Item No. **Report of the Head of Planning, Transportation and Regeneration**

Address 18 LINKSWAY NORTHWOOD

Development: Erection of a detached 7 bed dwelling with basement and habitable roof space to include 4 rear dormers including demolition of existing dwelling, replacement new wrought iron gates and piers and removal of the front boundary brick walls

LBH Ref Nos: **2695/APP/2021/466**

rev:	date:	description:
scale:	1 : 100	A1 date: 12 / 01 / 2021
drawing no:	1366 / P / 3	drawn: FJ
drawing:	PLANNING PROPOSALS, FIRST & ROOF FLOOR PLANS & REAR ELEVATION	
project:	LAND AT 18 LINKSWAY, NORTHWOOD, MIDDLESEX, HA6 2XB	
client:	DDA

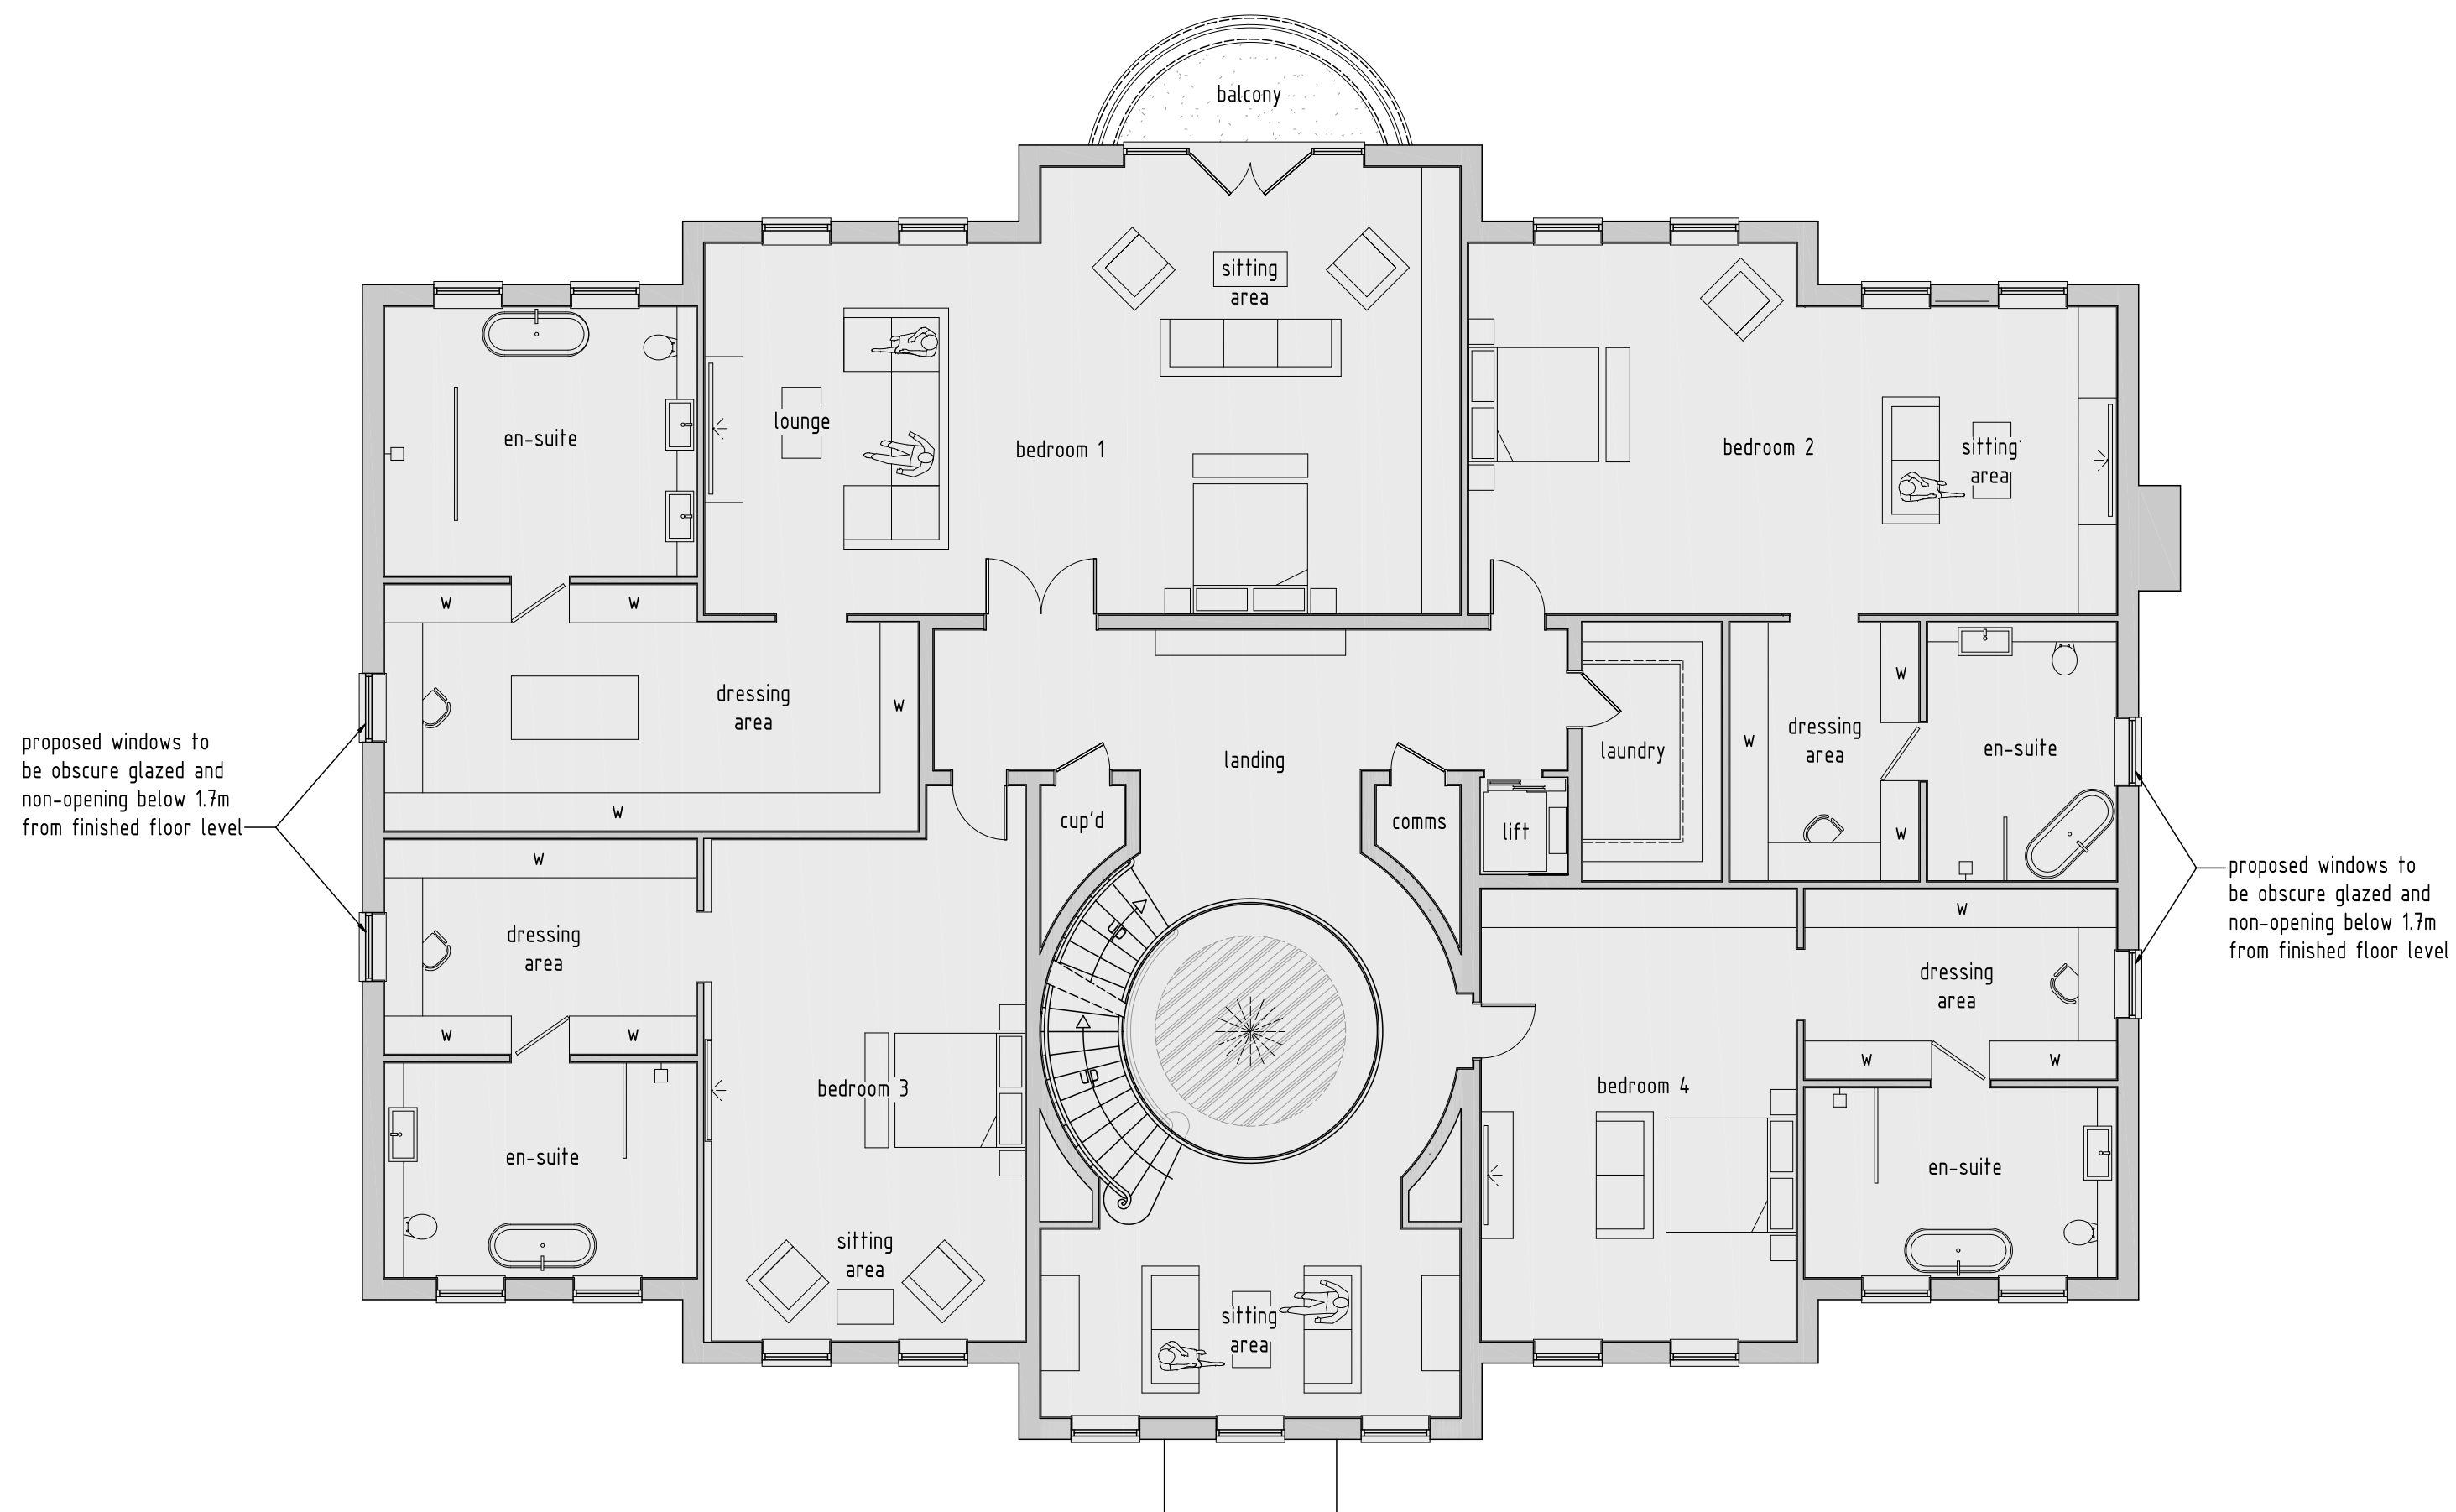
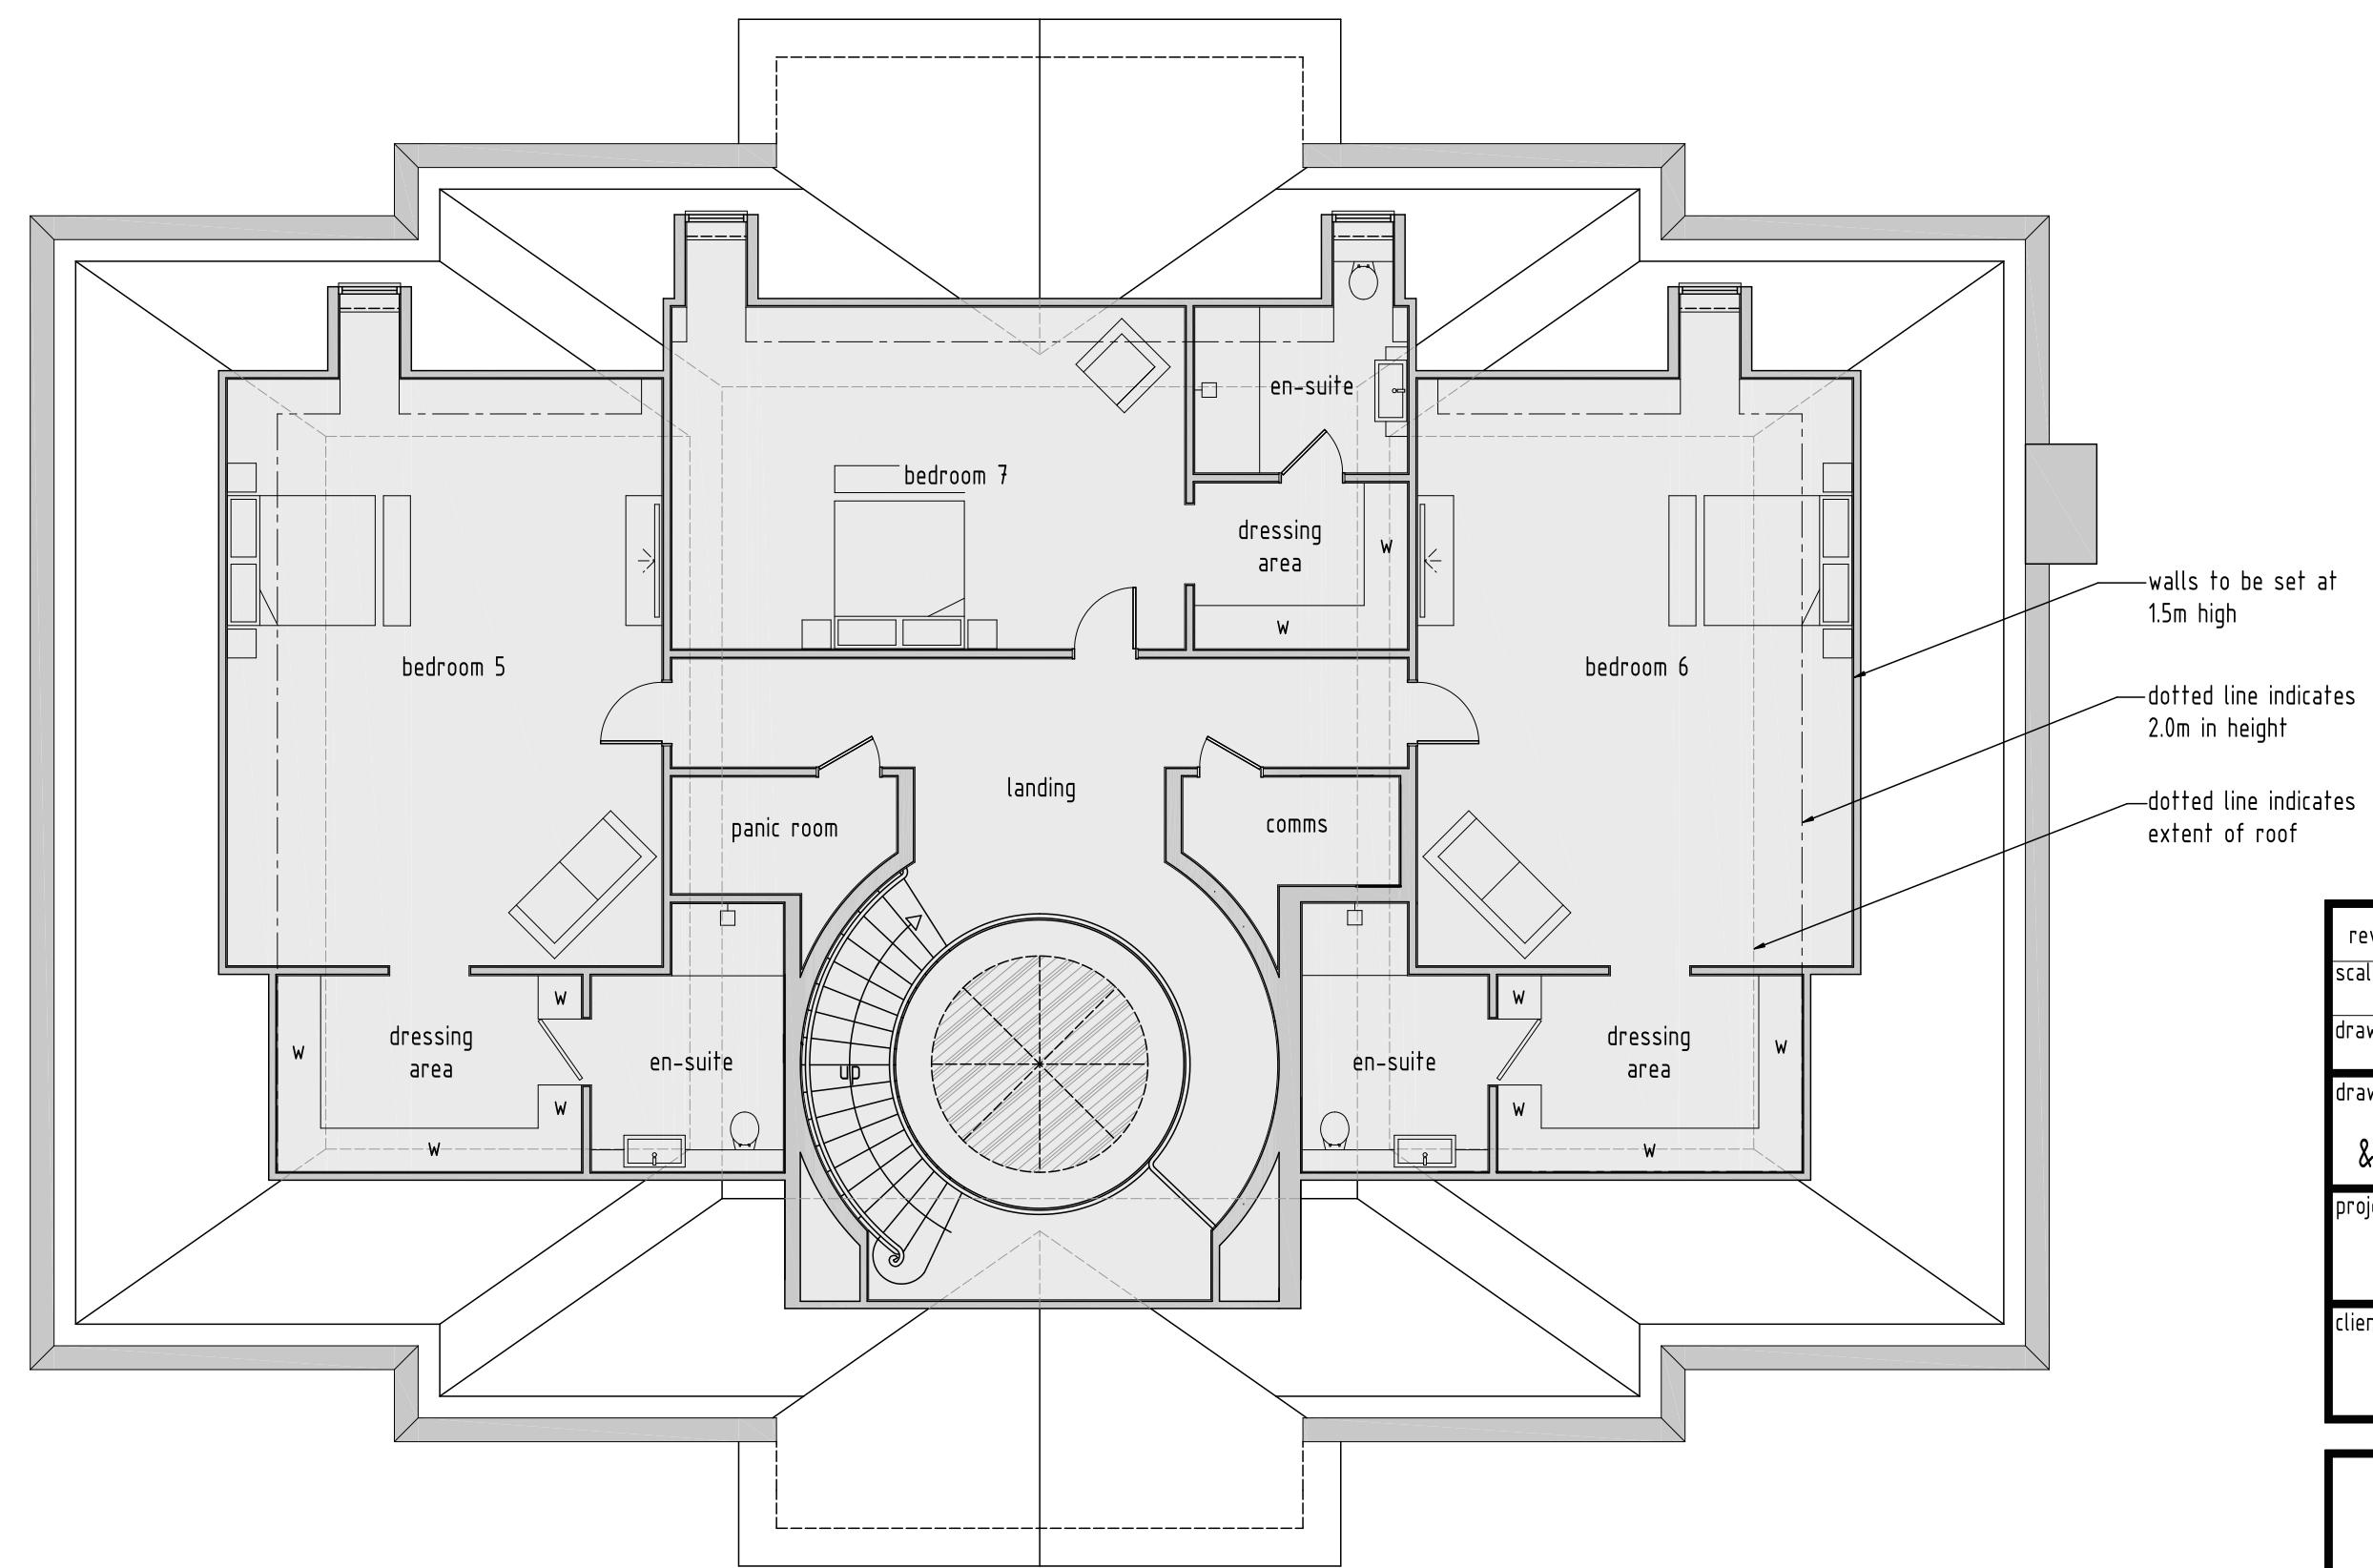
The proposed building has been designed in a 'polite' manner. It has a prominent mock Georgian appearance, with some classical detailing and a strong symmetrical frontage, however, fails to truly invoke the principles of Georgian architecture. The design is rather confused and includes a number of conflicting features. The windows appear as Victorian style sash windows, constructed in a modern material. The rear door openings have a 1930s appearance with horizontal glazing bars, similar to Crittall-style fenestration. The annotation refers to rendered quoins however points to a Tuscan style column.

The large pediment at roof level would unacceptably draw undue attention to itself along the street scene.

The proposed development would extend across the great width of the site with small gaps retained along the side boundaries. Whilst the footprint may be slightly smaller than the existing building, the scale and bulk of the built form is vast and further accentuated by the design and detailing of the building. The proposed columns elongate the height of the building and the large crown roof exacerbates the bulk of the development.

The inclusion of the large areas of crown roof would continue a detrimental precedent within the ASLC. Crown roofs are not a traditional or original characteristic feature of the ASLC. New developments should be able to achieve fully hipped roof forms.
